EPC STORMWATER REVIEW COMMENTS
 IN ORANGE BOXES WITH BLACK TEXT

Add "PCD File No. PPR2317"

WOODMOOR WSD NO. 1
 WELL NO. 22
 EL PASO COUNTY, COLORADO
 SITE DEVELOPMENT PLAN

SHEET NO.
FIG-1

SHEET NO.  
**FIG-1**

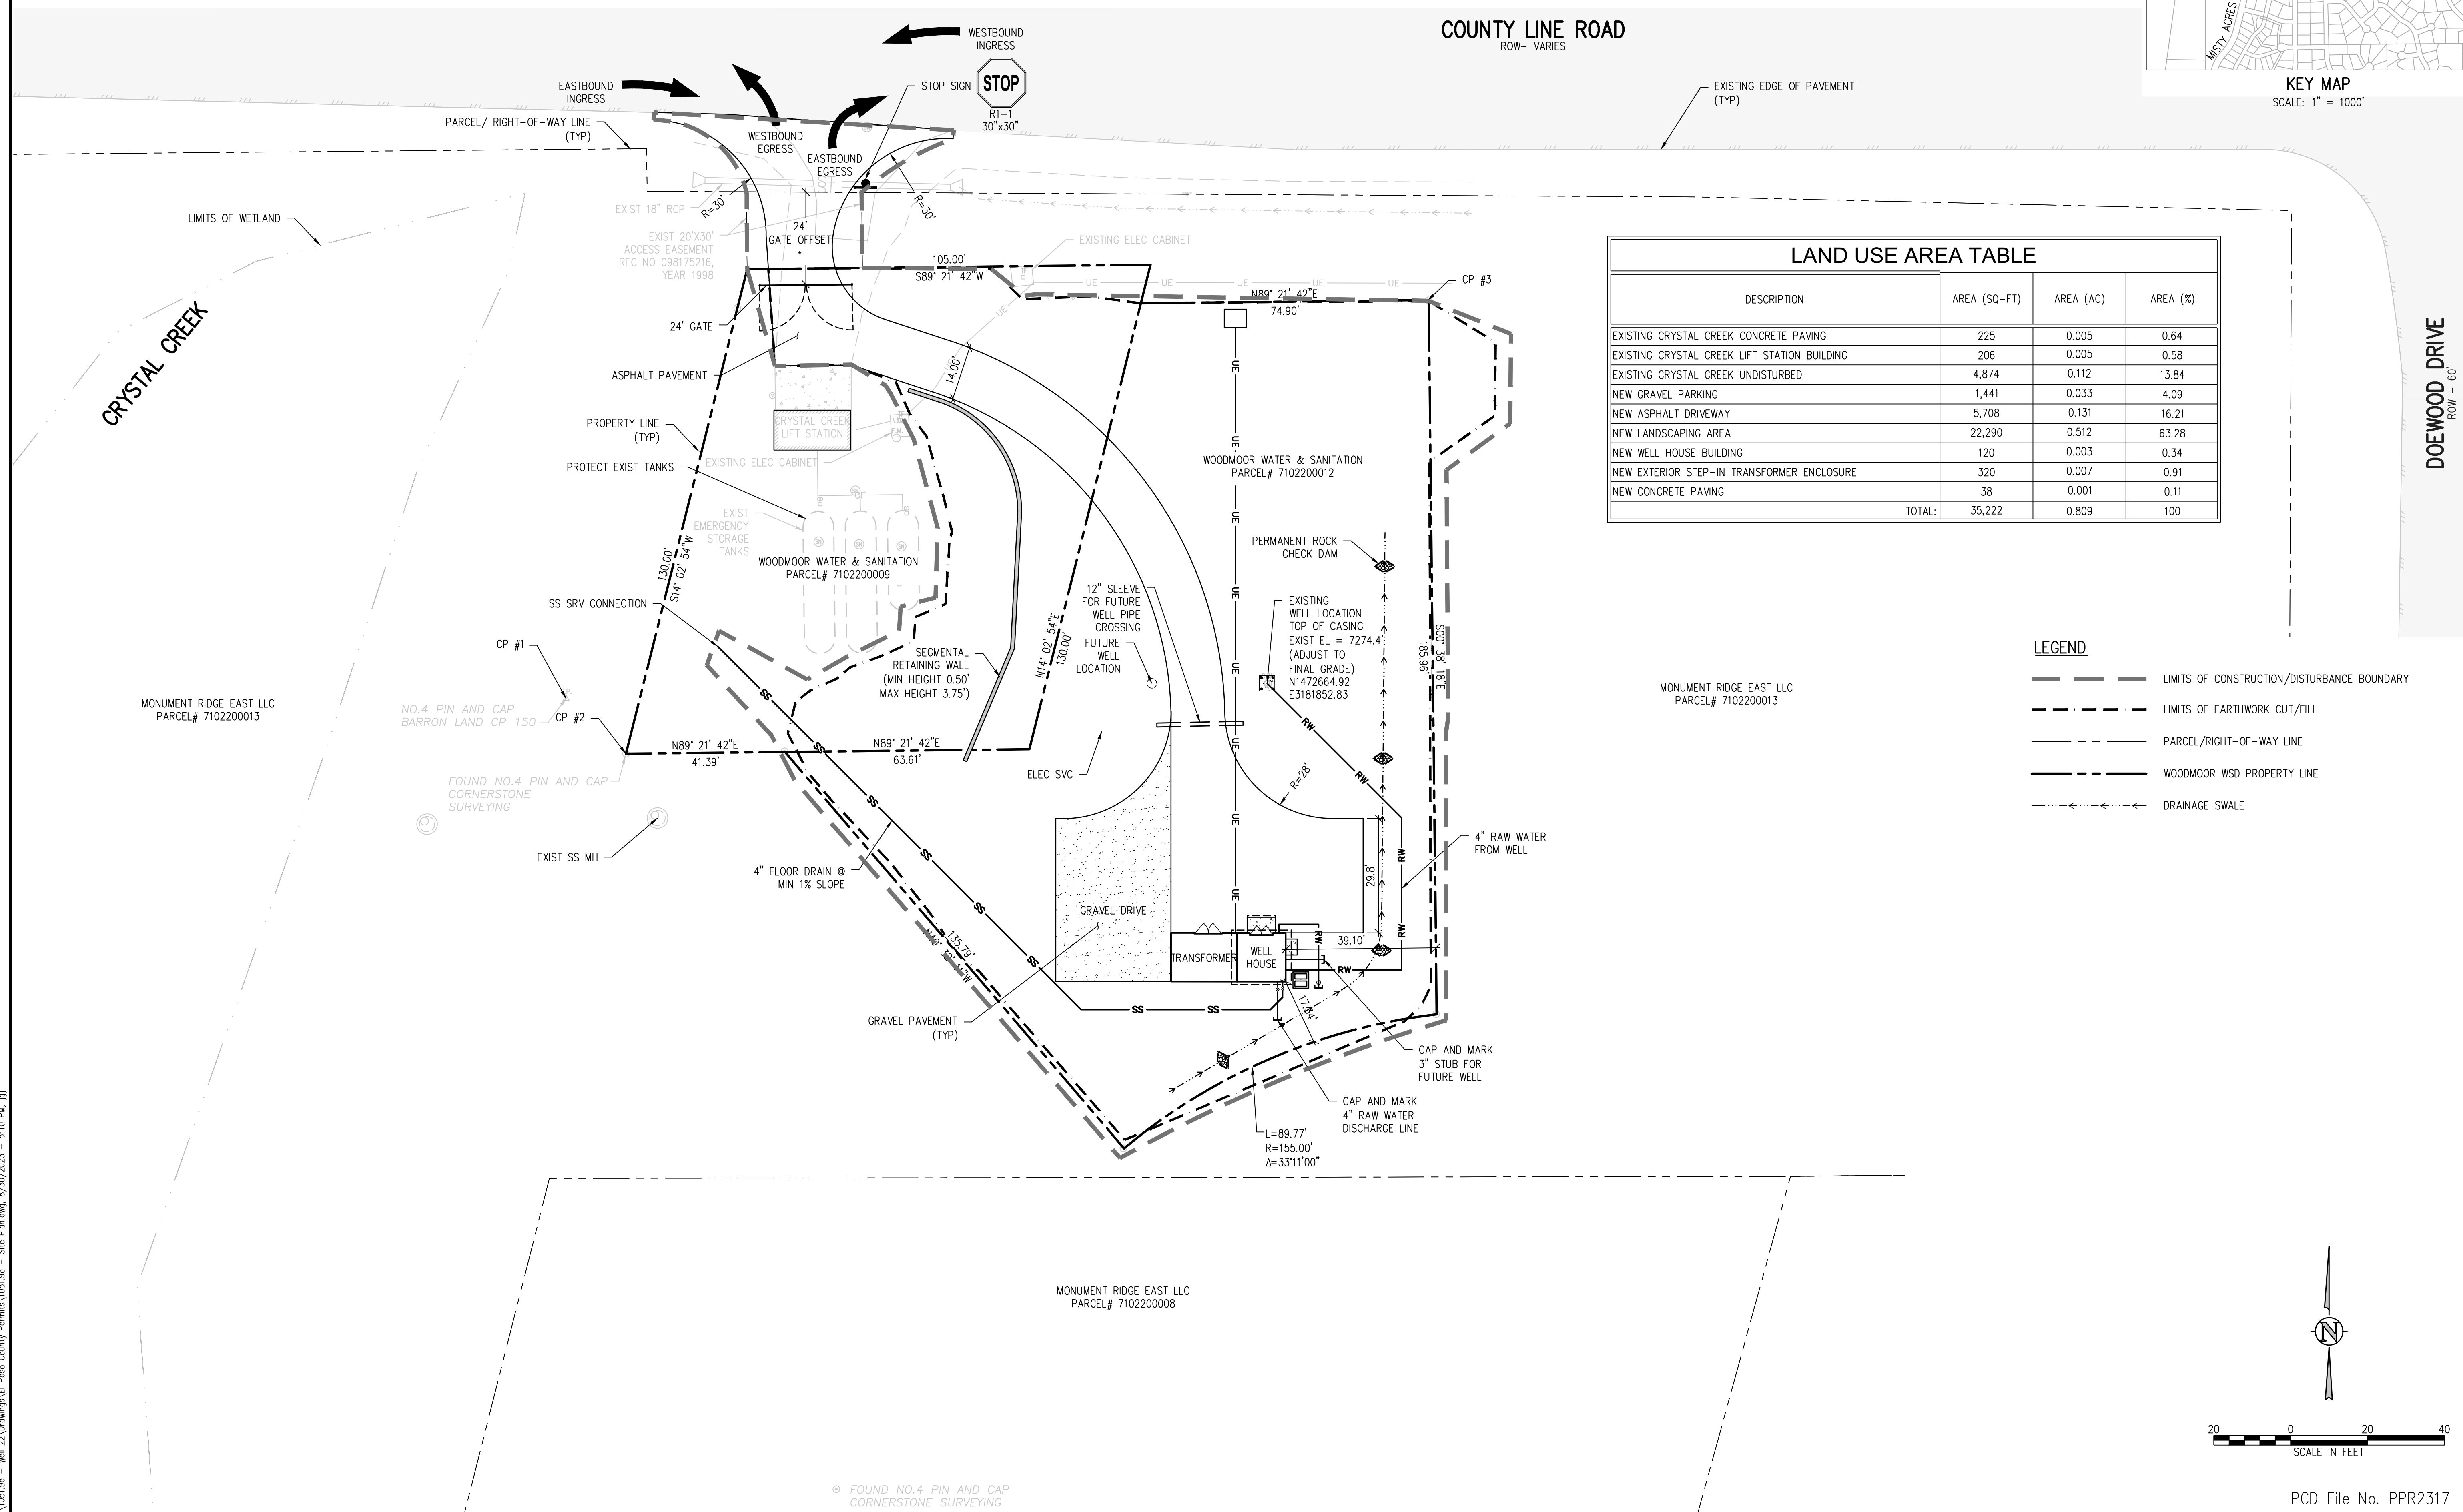
Please depict:
 -Traffic ingress/egress on property
 -Location and height of any fencing, walls, or berms
 -If there is signage:
 . location and dimensions
 - Lot area coverage percentage
 - Open space, landscaping, and impermeable surface percentage
 - Total gross building square footage

Should this well be existing? Was this well built with filing CDR223? Verify. The existing condition for this project should be the proposed condition of CDR223.

Label curb return radius. Per ECM Table 2-32 the minimum curb return radius should be 30'.

Please label driveway width. The maximum driveway width for a two-way commercial access is 40'.

GEC Checklist Item DD. Note: Regional Building Department permit required for all retaining walls greater than or equal to 4 ft in height.

Put this linestyle in legend and clearly label.

Provide riprap or other erosion protection in ditch at the discharge location.
